Planning Act 2008 (as amended) – Section 88 and the Infrastructure Planning (Examination Procedure) Rules 2010 (as amended) – Rule 6

Application by Millbrook Power Limited for an Order Granting Development Consent for the Millbrook Power Project

**Issue Specific Hearing on the Draft Development Consent Order 2.00pm,
Tuesday 13 March 2018**

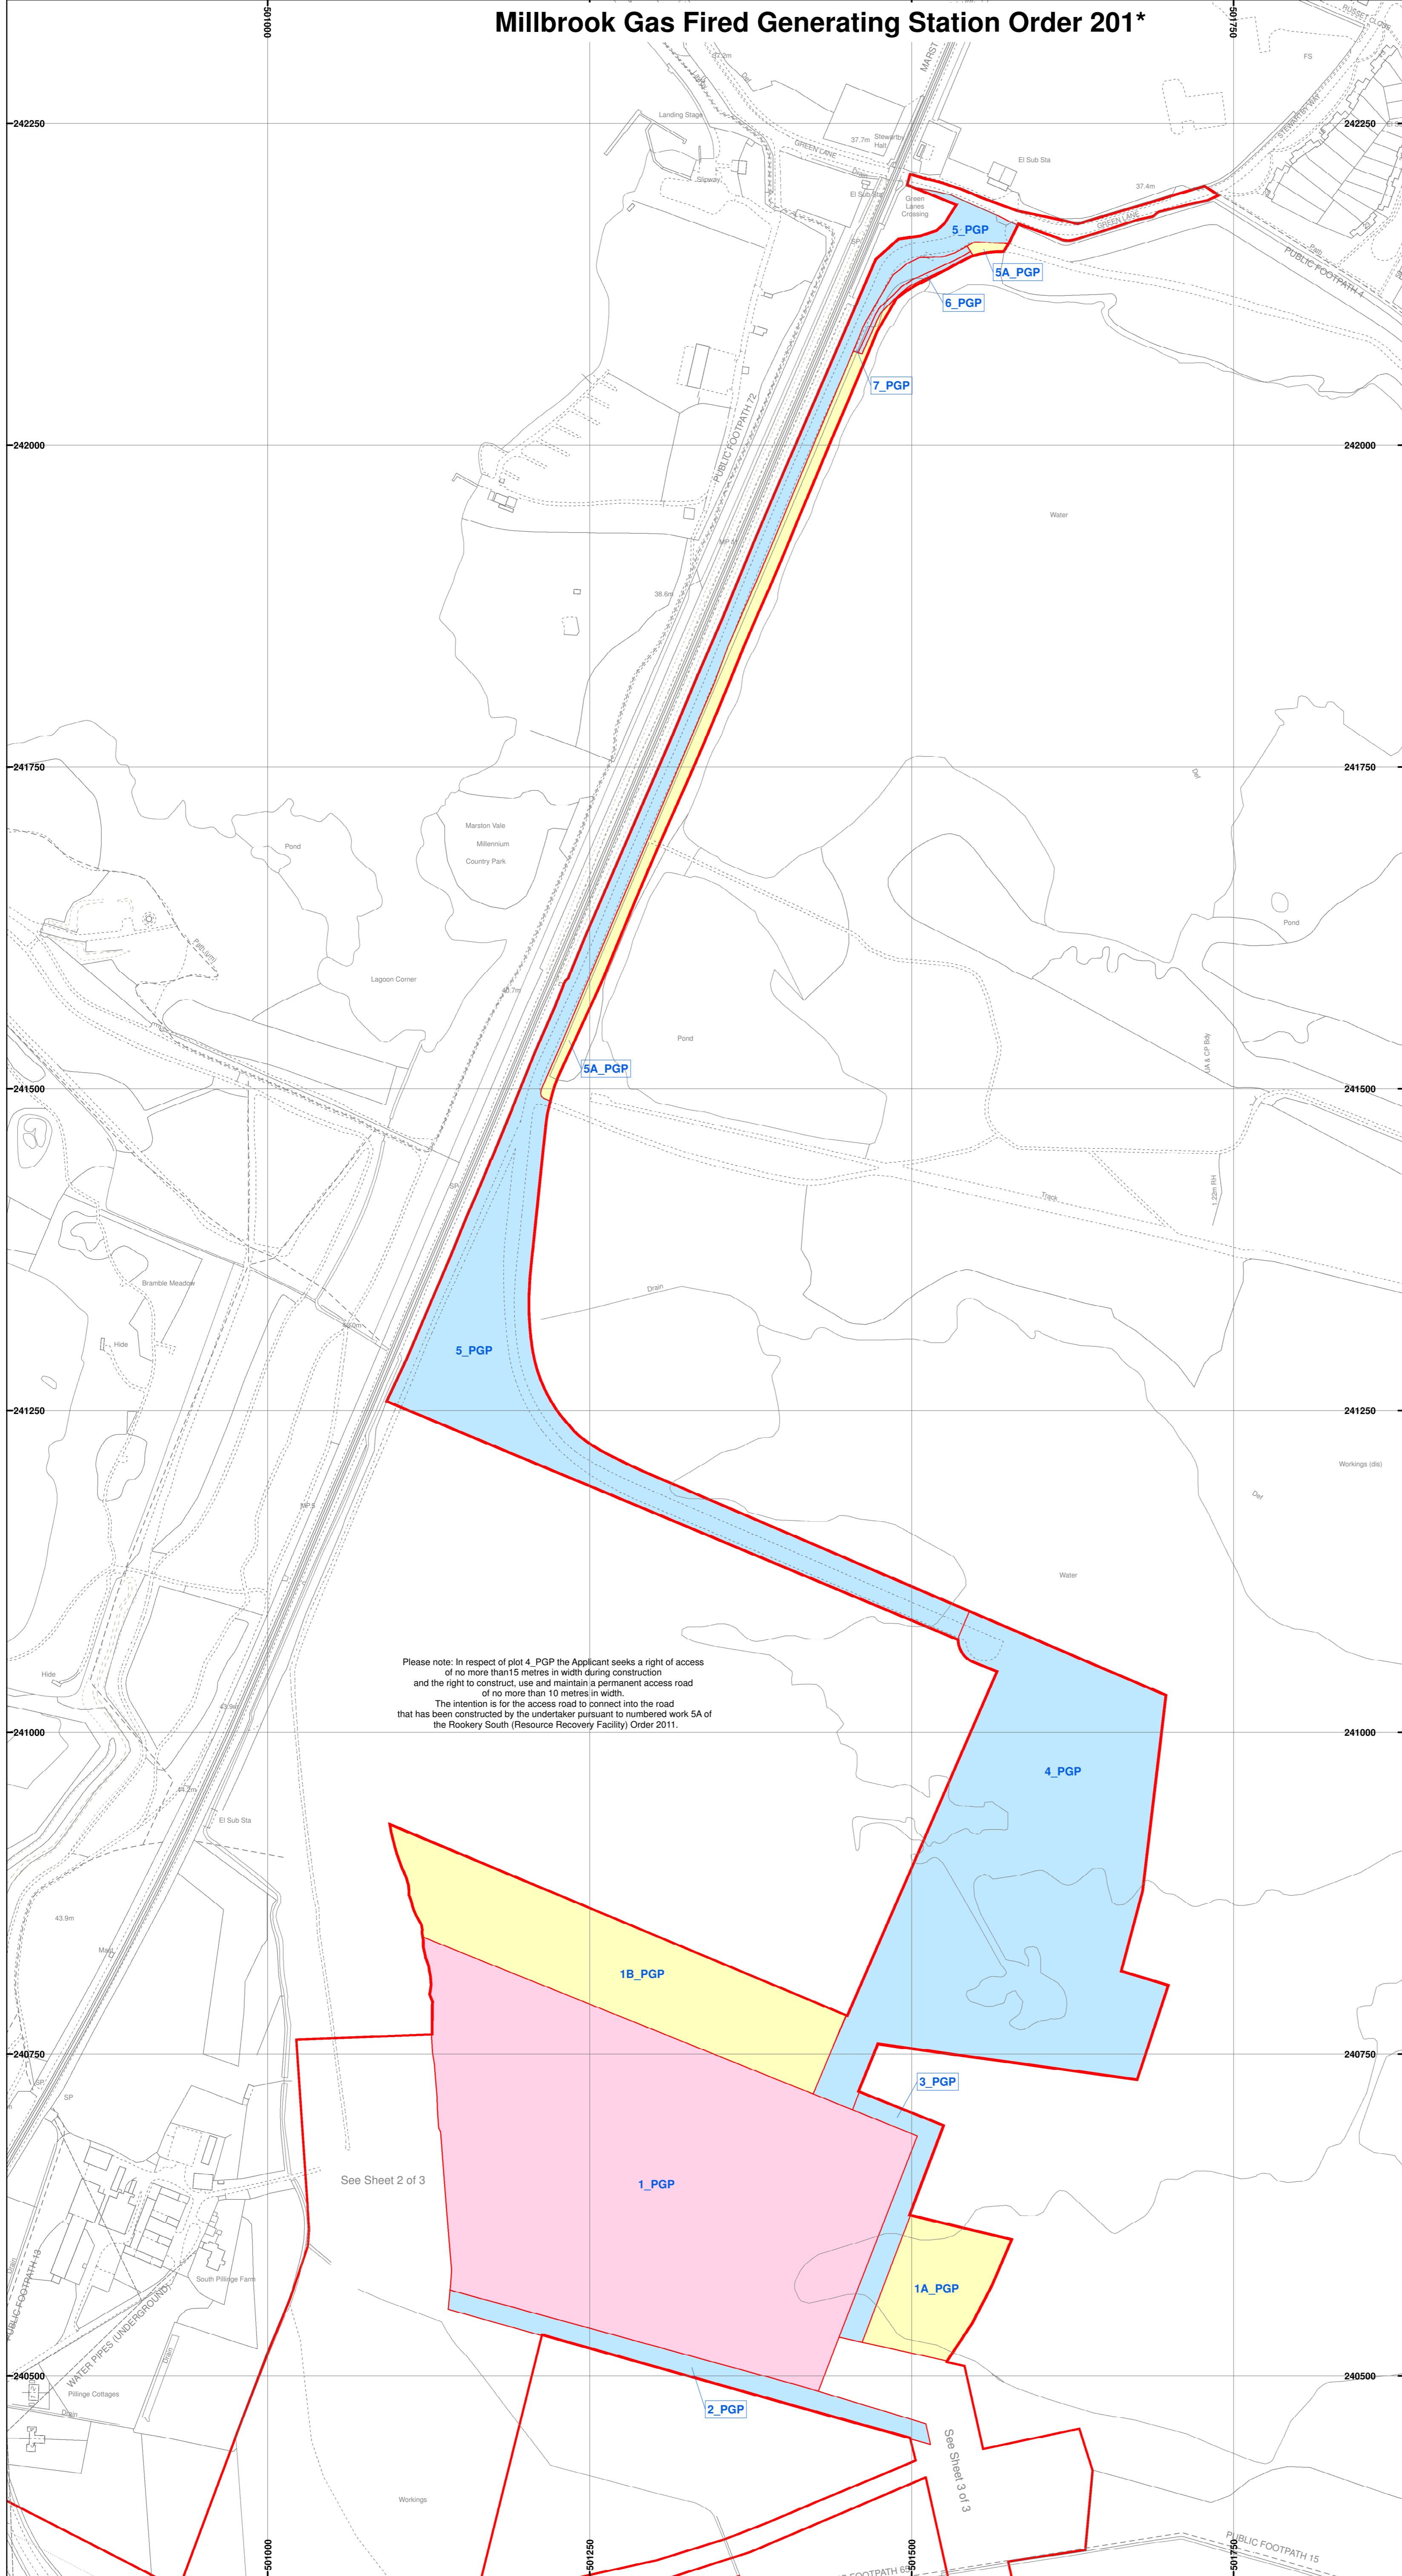
- 2.6 Article 22 - authorises the compulsory acquisition of rights over the Order land. Document ref 2.5 drawing no J0008128-101 shows a substantial area marked as 4_PGP over which compulsory rights are sought. The note on the drawing states that a right of access of no more than 15m in width is required but the whole area has been included as a limit of deviation. This area is the land on which the main Rookery South development would take place.

- What are your reasons for including all of 4_PGP?
 - Scope for defining a specific access route?
- 2.7 Article 39 - provides for the modification and amendment of the Rookery South (Resource Recovery Facility) Order 2011 with the detailed proposal set out in Schedule 11. The EM sets out the basis on which the Secretary of State could use s120 of PA 2008 to make such a modification.
